Two storey rear and side extension. Removal of existing conservatory and replacement with single storey childrens room (also at rear). Enlargement of attached garage at front. Removal of mock Georgian portico at front and construction of matching enclosed porch
65 Golden Avenue East Preston

Thank you for your internet comments made on 4th October 2012 and recorded as follows:

SECTION B - B

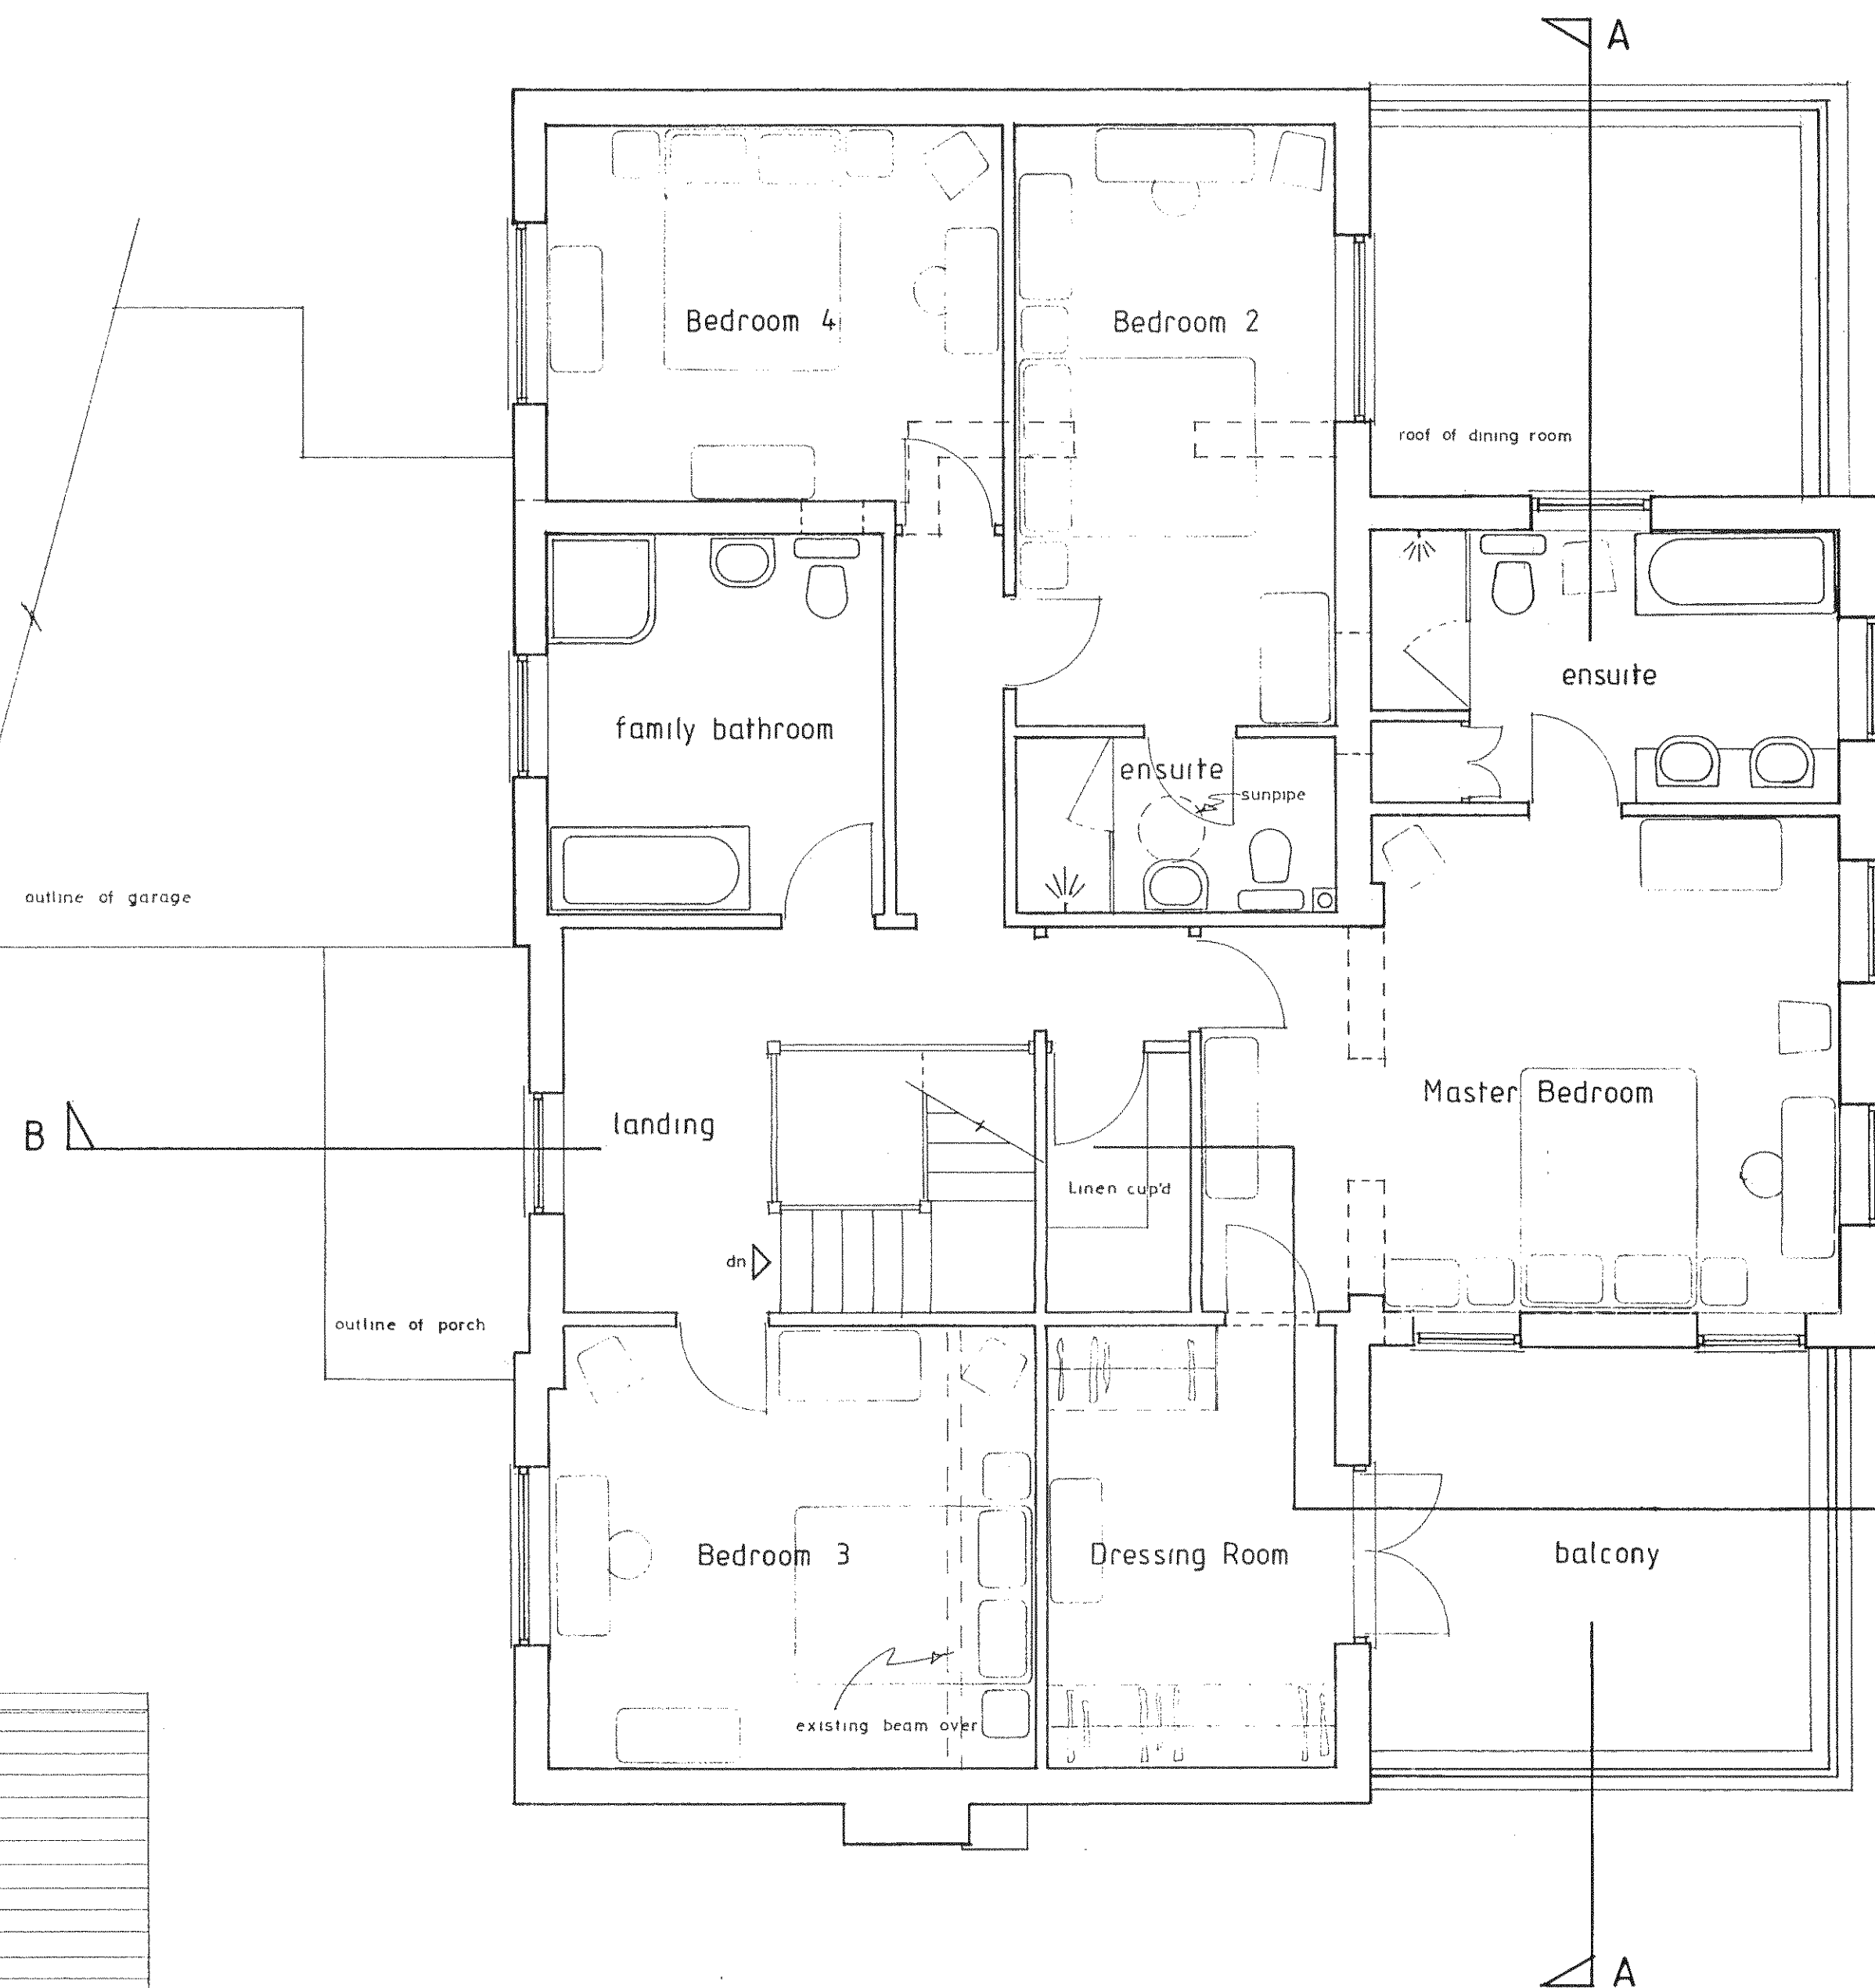
Council objects to the application considering that the rear first floor extension windows and balcony will be intrusive to neighbouring properties, particularly to the south of the property. Council considers:

- 1) there should be obscure glass in the new first floor bedroom windows facing south*
- 2) there should be a privacy screen fitted to the southern end of the new proposed balcony. (Council accepts that this might negate the need for obscure glass in the most westerly of the new first floor bedroom windows facing south referred to above & but it is unclear from the drawings supplied).*
- 3) there should be obscure glass in the north facing window of the new en suite bathroom.*
- 4) there should be a condition preventing access to the flat roof over the dining room except for repairs and maintenance.*
